WILLOWTREE PLANNING

REF: WTJ20-395

Wentworthville Northside West Clinic Extension SSD-17899480

TABLE 1. COUNCIL & AGENCY COMMENTS 21.09.2022		
A.	Cumberland Council Response	Applicant Response
1.	Council maintains the objection to the development application with regard to the proposed breach in the development standards. Council notes that the proposal has attempted to address the issues raised notably by reducing the building height breach from 30.7% to 24.5%. Matters raised in the objection previously submitted however continue to remain.	A comprehensive Clause 4.6 variation was submitted with the RtS which addressed the mandatory components of Clause 4.6, being: 1. Objectives of the standard 2. Objectives of the zone 3. Why the standard is unreasonable and unnecessary 4. Environmental planning grounds for the variation All of the above have been addressed satisfactorily which demonstrate the variation is supportable and justified, having regard to the site conditions, nature of the use, surrounding land use and resultant impacts.

Overall Site Plan - Ground

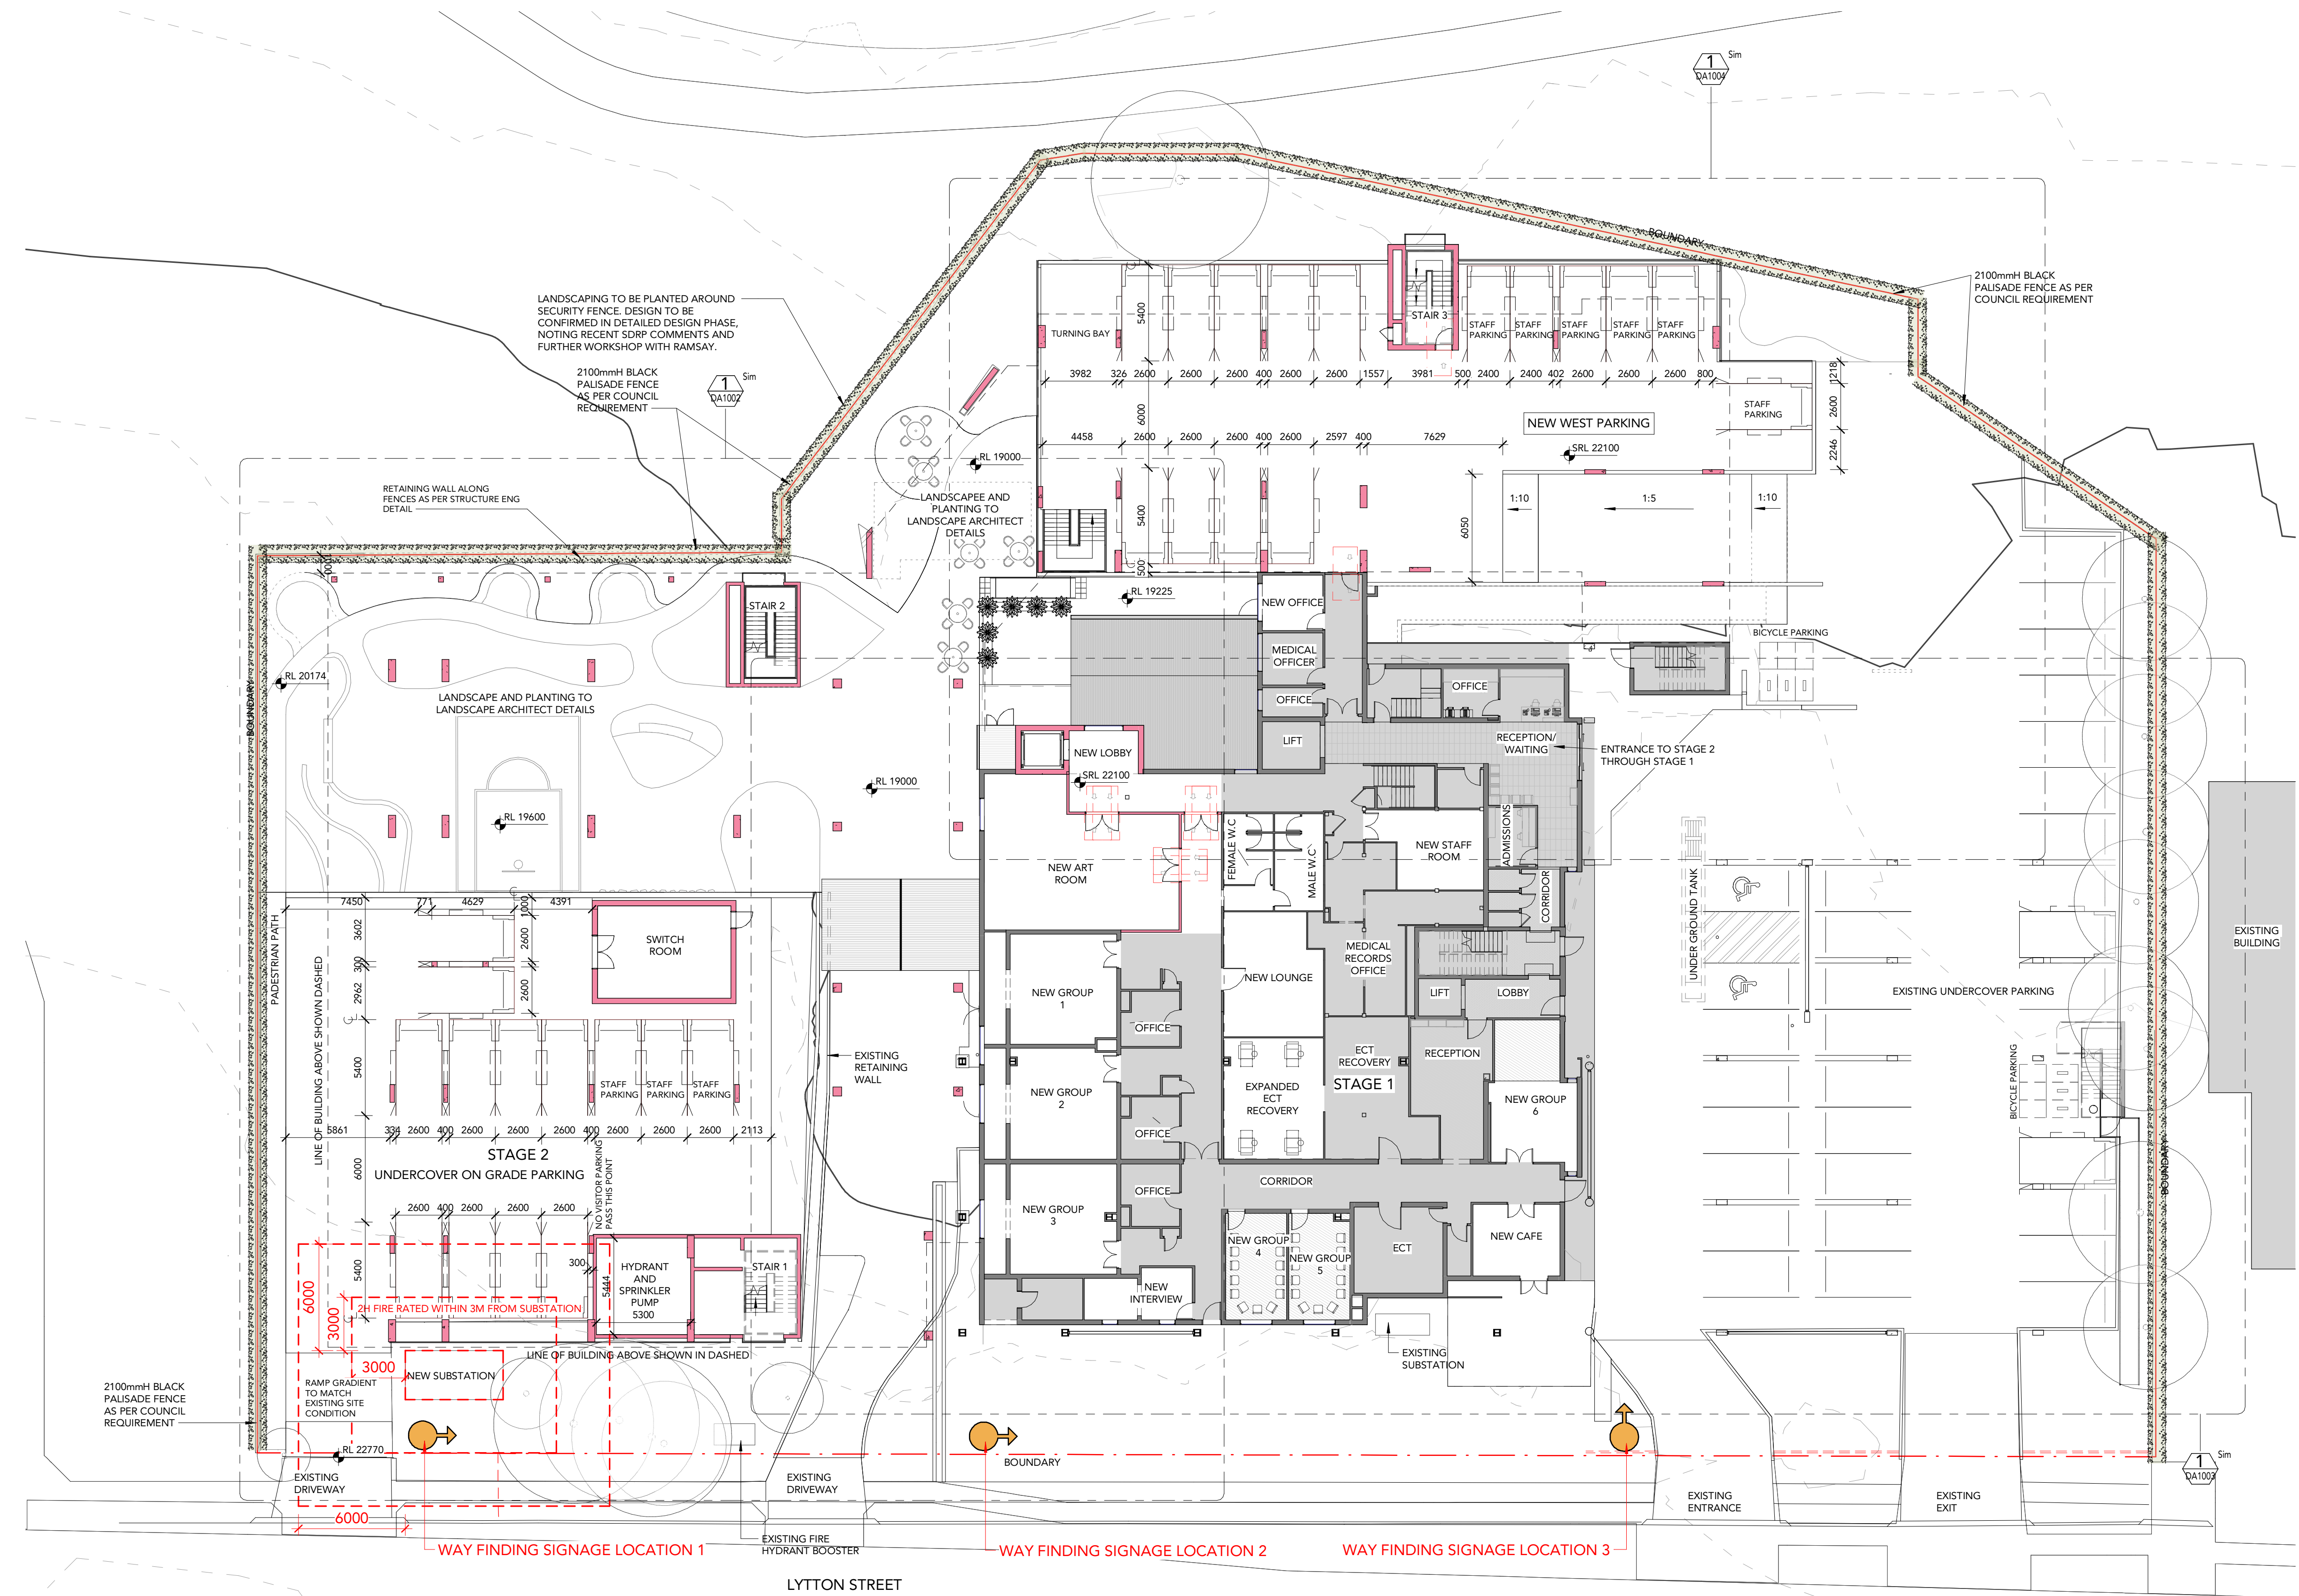
6.	The proposed substation shall be located in area where it is clear of the realigned Council's stormwater easement.	Noted – to be positioned in line with Endeavour Energy requirements and not within the Council Easement.

Given the available front building setback, relocating the new padmount substation to the front boundary could be preferable. This should overcome the need for any fire rated construction to the building, avoid the need for an easement for the associated underground cables and is preferable from a prudent avoidance perspective.

Unable to move due to Council Stormwater pits.

SECTIONS

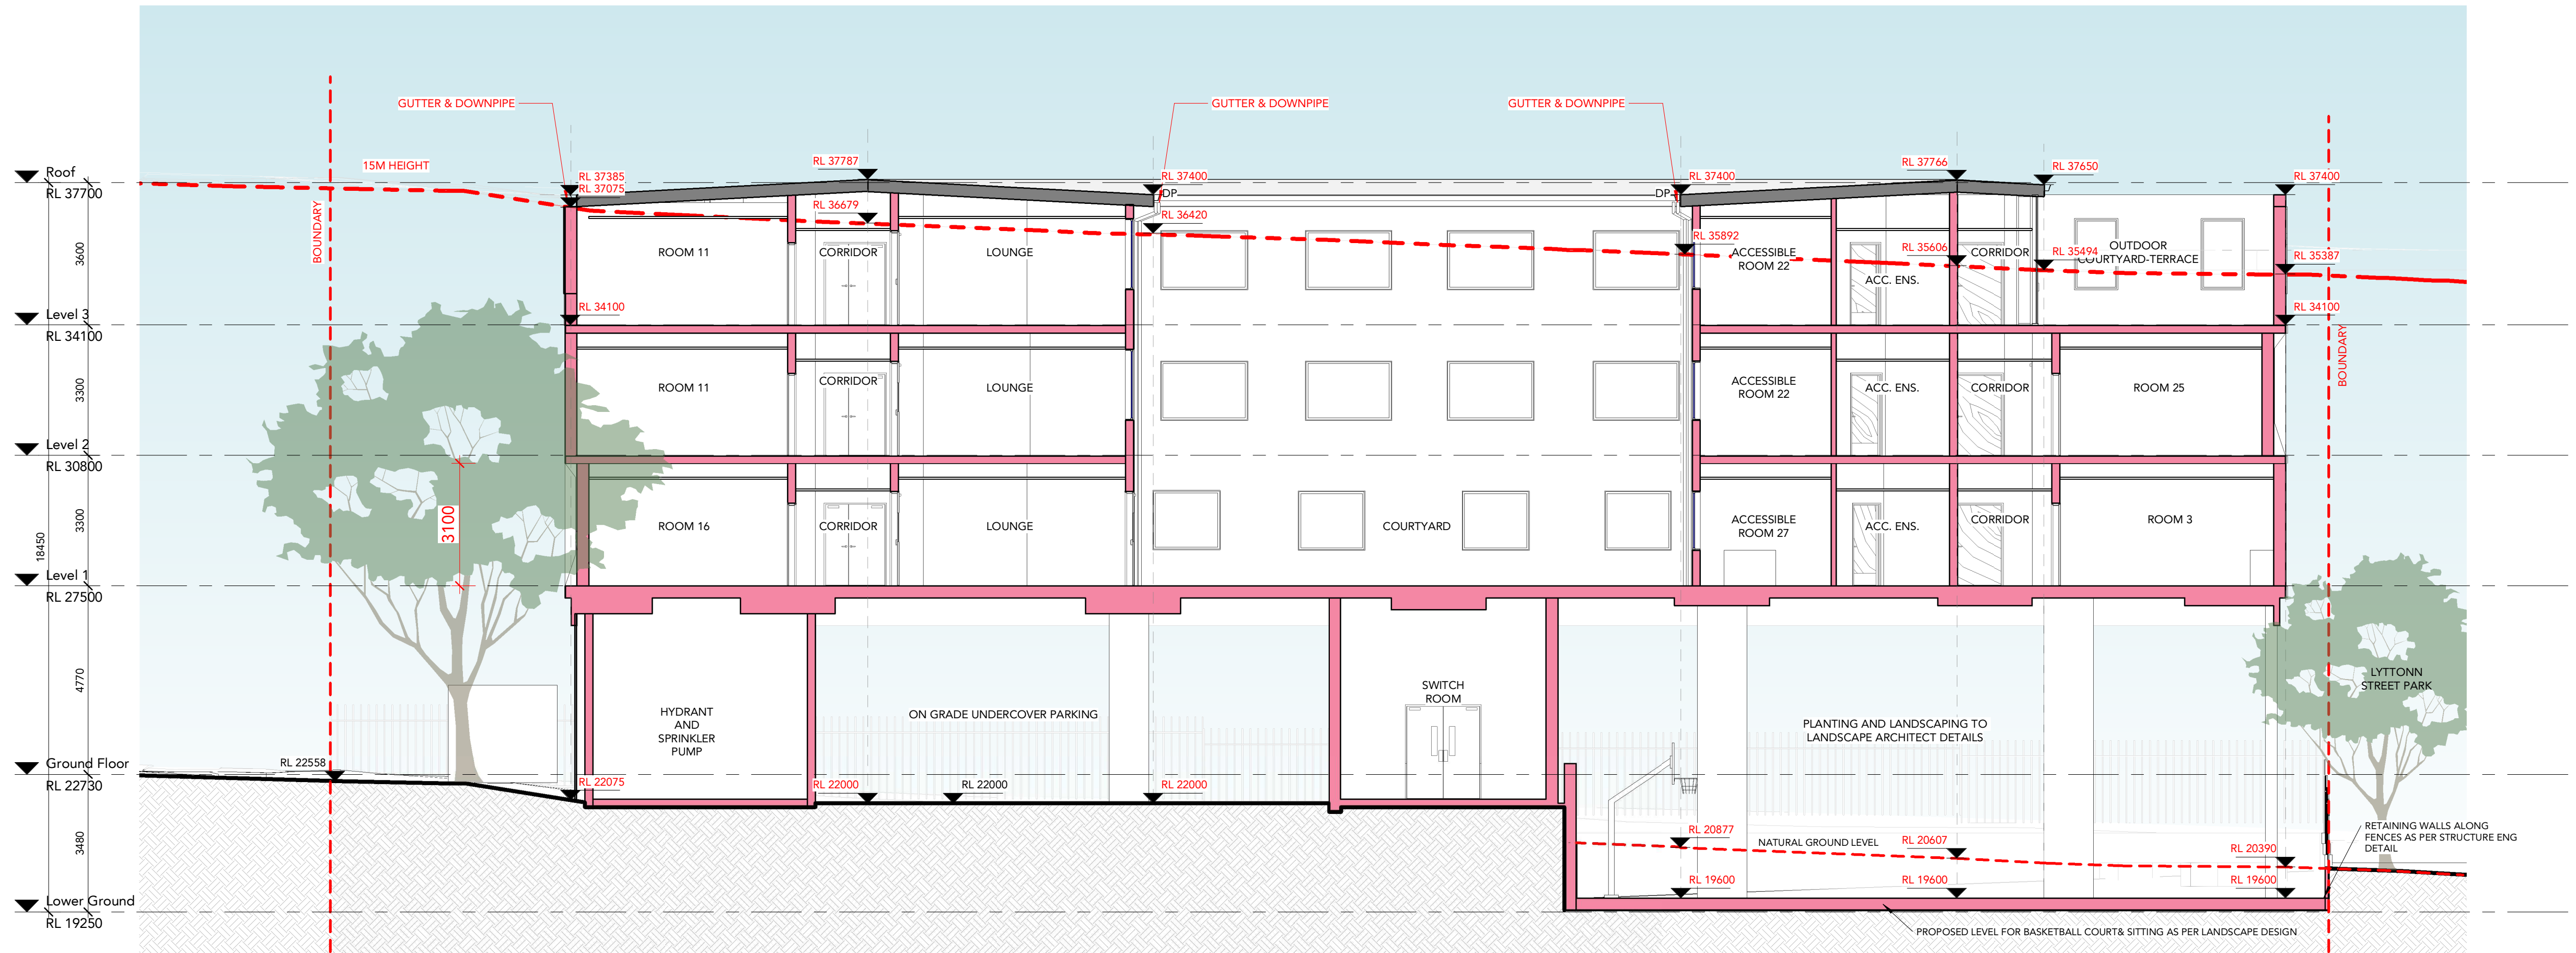
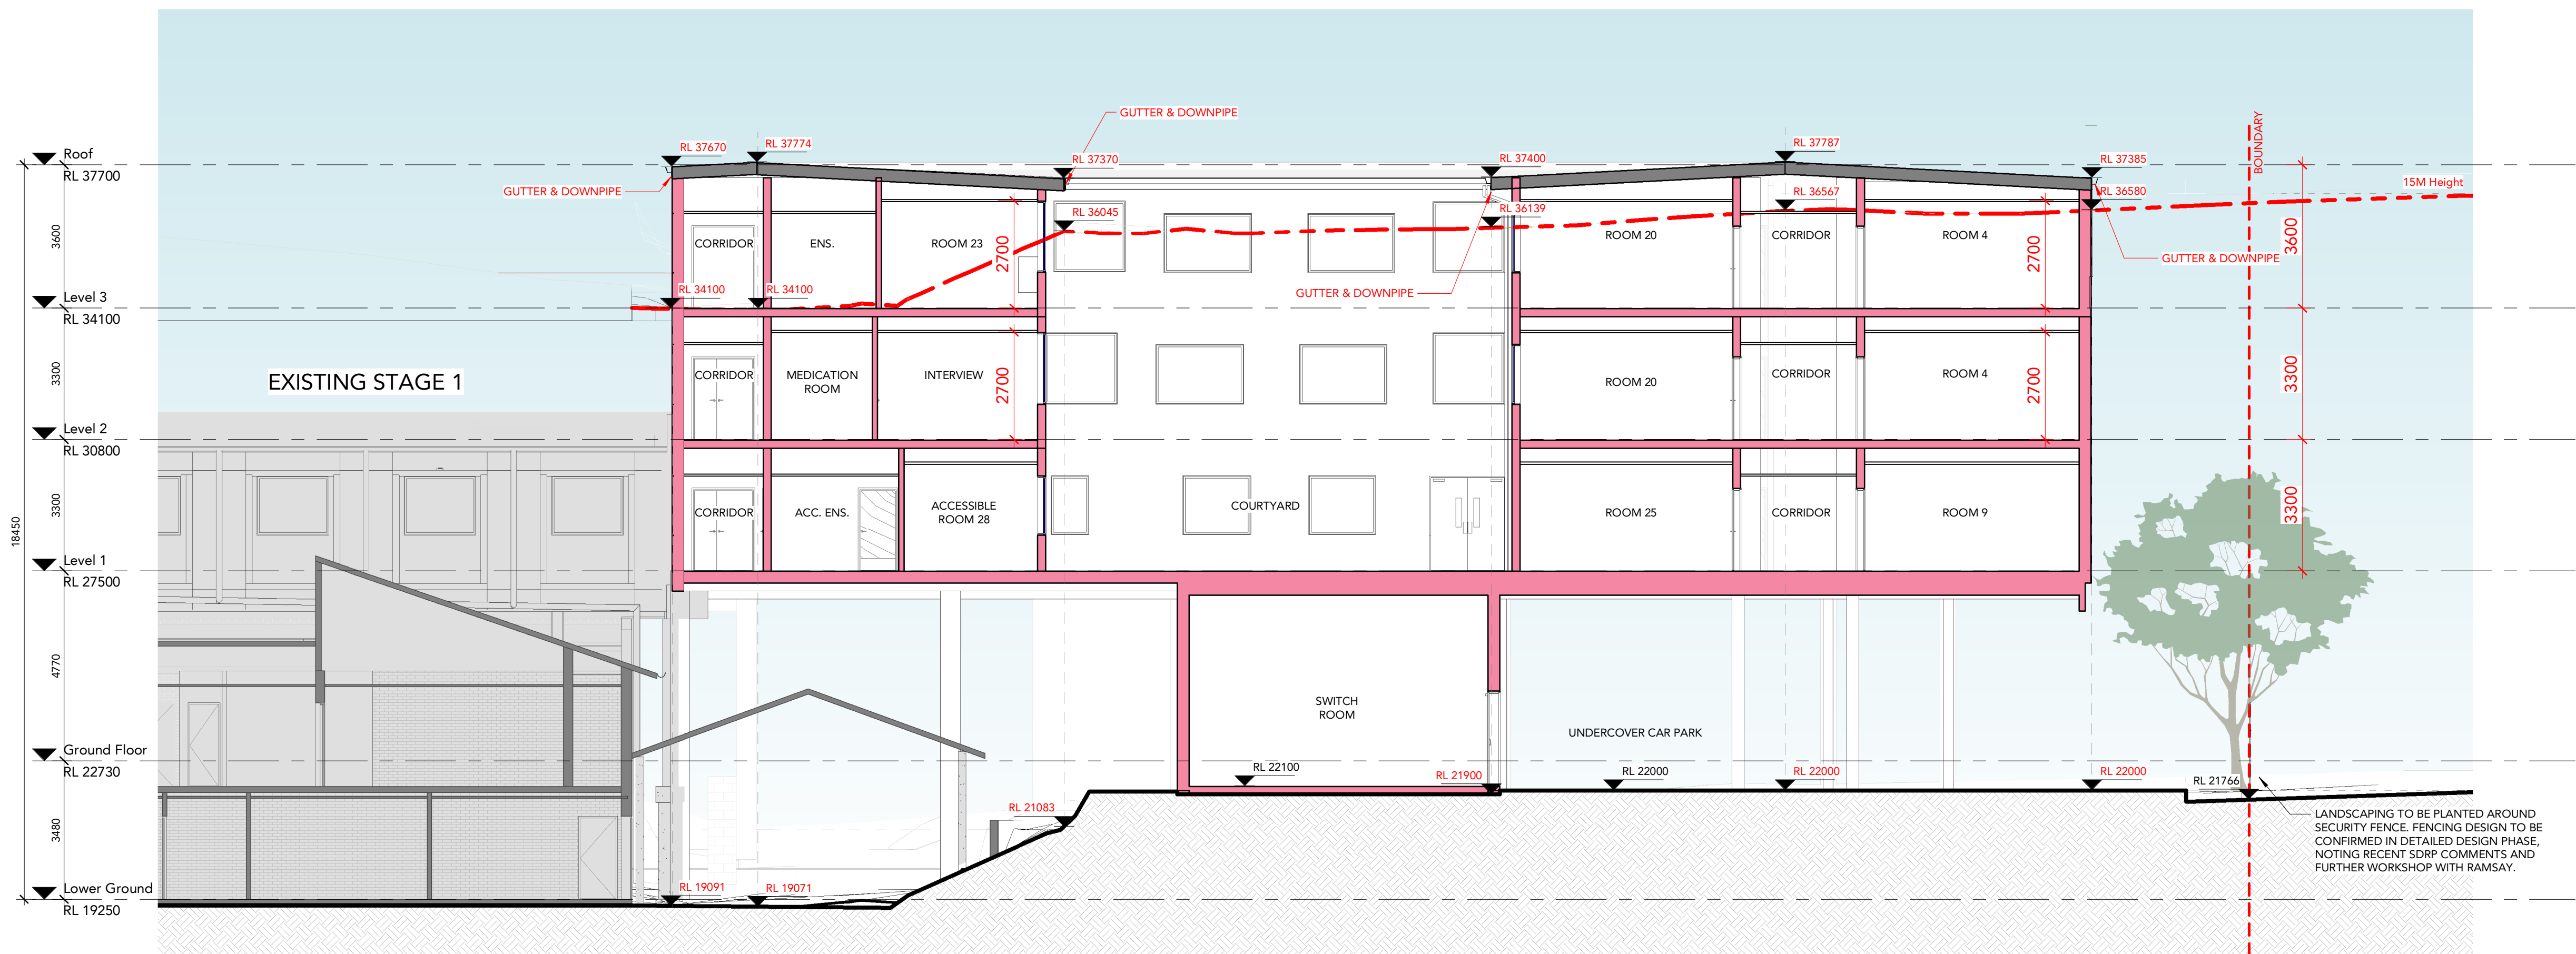
2.	Council considers that the proposed building component where it contravenes the permitted height standard by 24.5%, or 3.67m above the maximum height of 15m, to be inconsistent with the bulk and scale of the existing adjoining developments and the future character envisaged for the immediate locality.	The location where this occurs is centrally located within the proposed building. The Lytton Street frontage is compliant with the 15m height limit. The perceived bulk and scale because of the breach is minor and wholly consistent with the operational nature of the existing hospital on the site. The impacts on surrounding land are minimal and inconsequential in terms of privacy, views, solar access and bulk and scale.

3.	The amended section plans indicate that the proposed floor area situated above the permitted building height line particularly contains proposed rooms that will be used as habitable areas, which in turn results in the breach of the FSR standard by 9.45%.	Any rooms above the height limit will be for patients. The rooms are not for typical residential accommodation, rather health services for mental health. The nature of the use and separation from any surrounding properties should give comfort that there is minimal to negligible impact in this respect.
